Application for a Non-Material Amendment Following a Grant of Planning Permission

Reserved Matters submission for the erection of residential development (Use Class C3) with associated landscaping, access/egress, car parking, drainage, and other necessary infrastructure

22/01995/RM

Proposed Materials Plan : NO 2824 03 AC 0009 c

Drawing Title
Proposed Materials Plan

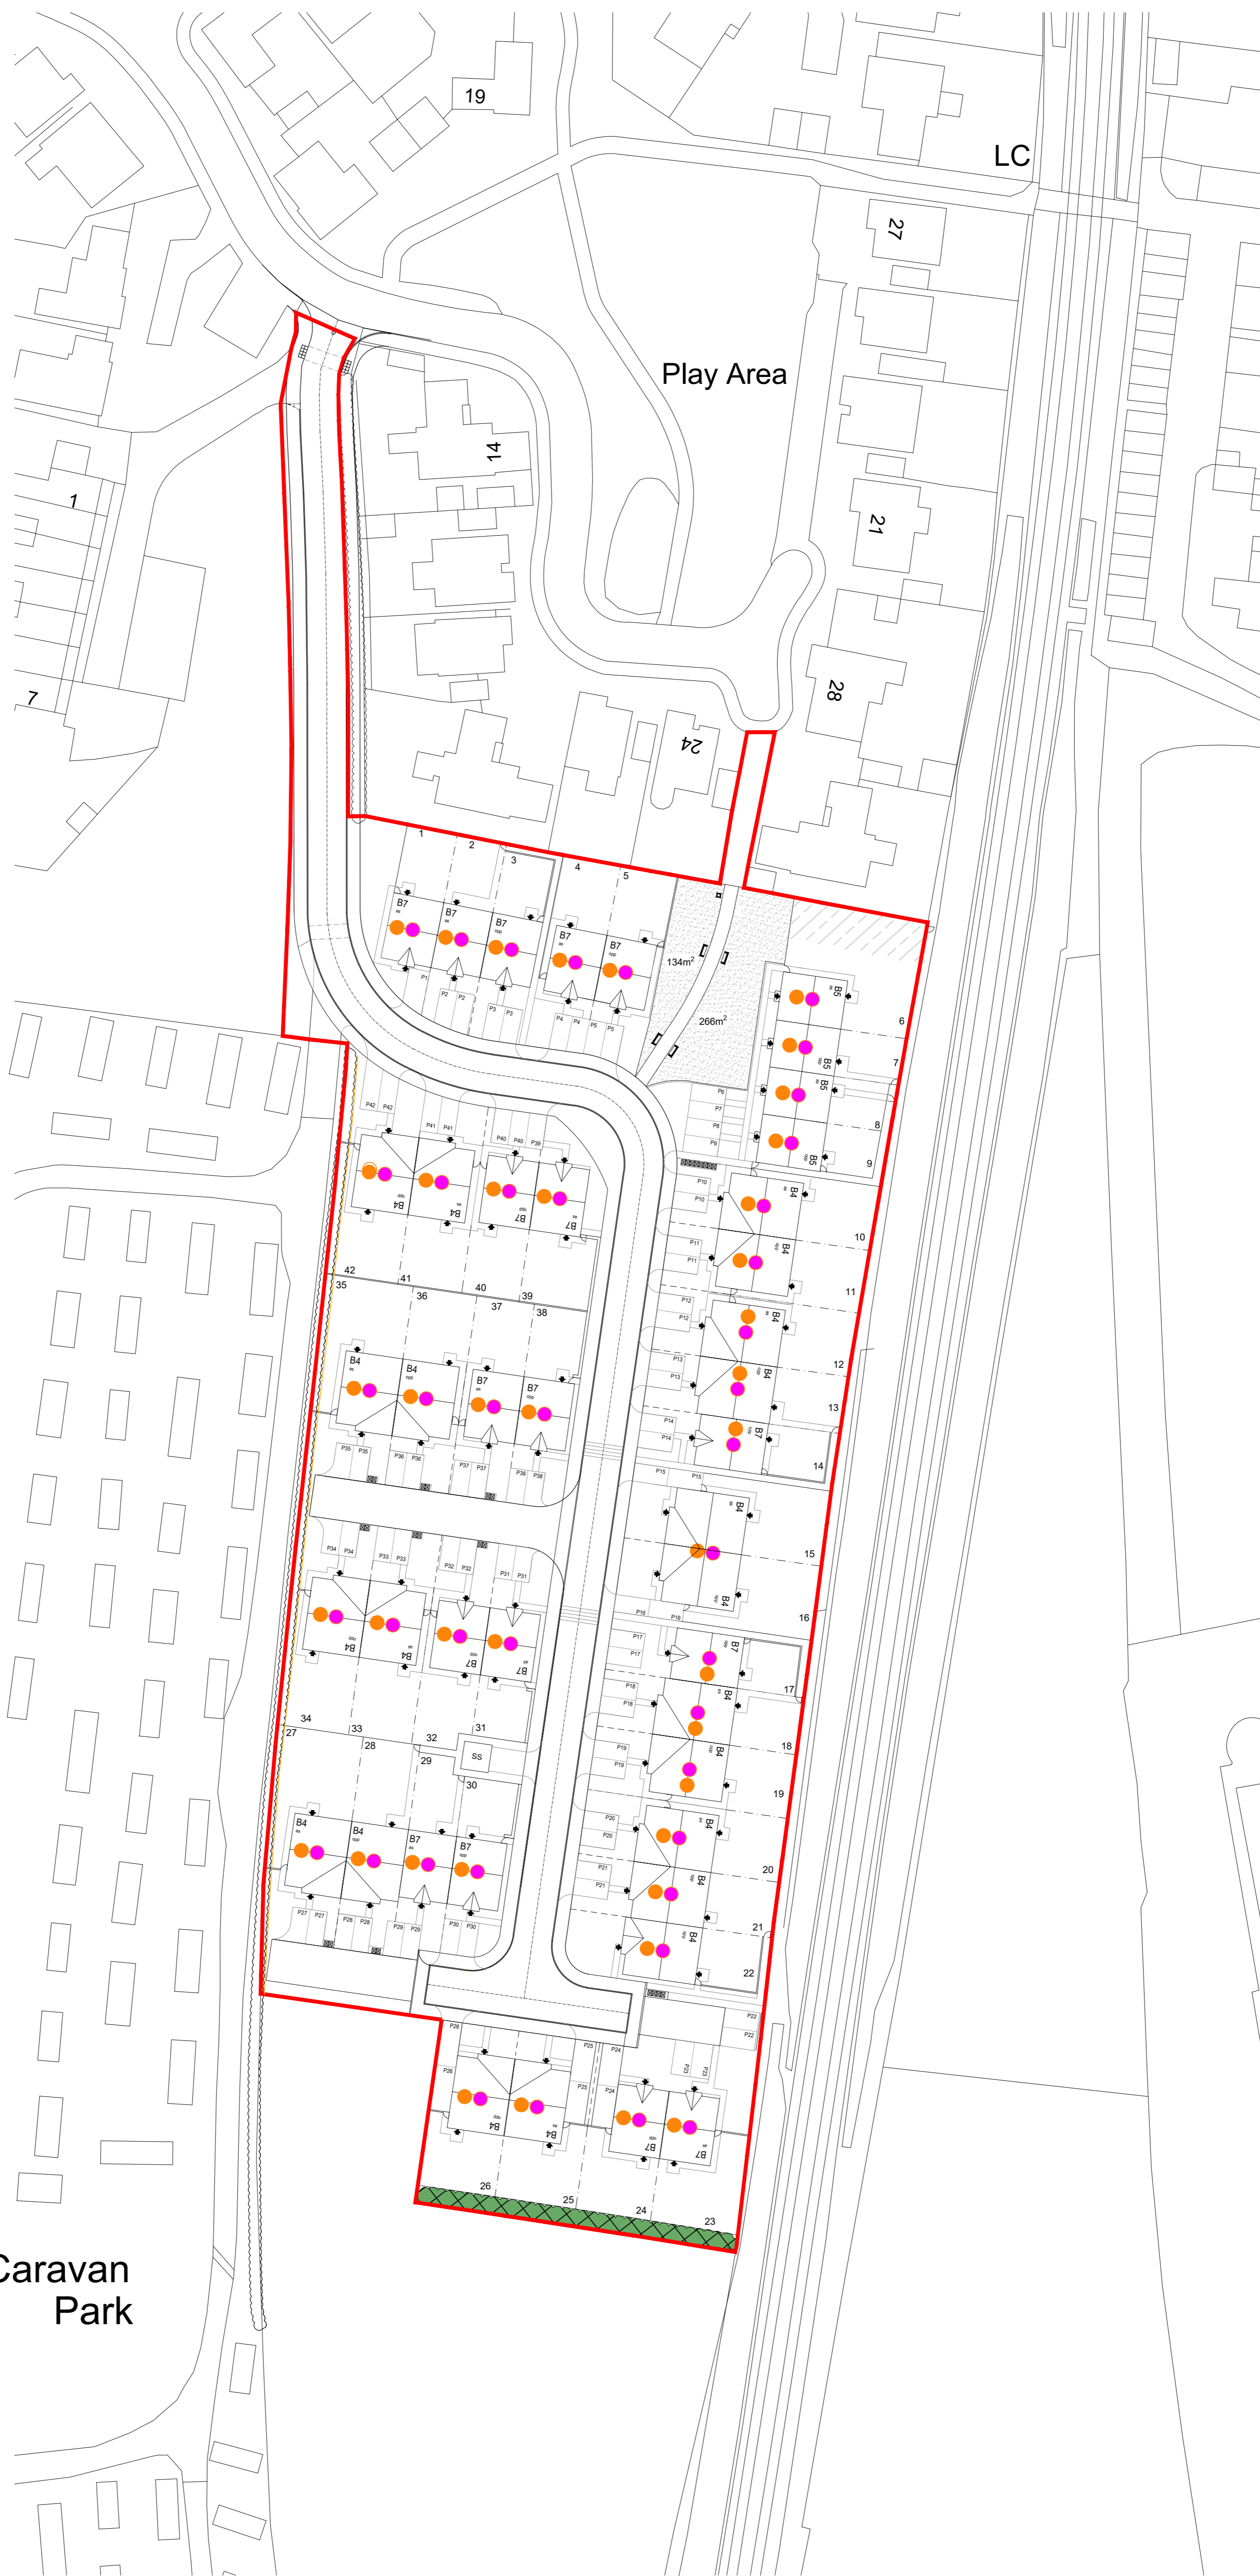
Proposed new facing brick to bungalows: We are proposing a change from the original approved facing brick (smoked orange multi gilt stock by Weinerberger) to a Forterra Clumber Red Mixture.

Further to an internal design, construction and sales review it has been decided that the 'Forterra Clumber Red Mixture' is a more appropriate material for this site in terms of appearance.

Proposed Materials Plan : NO 2824 03 AC 0009 D
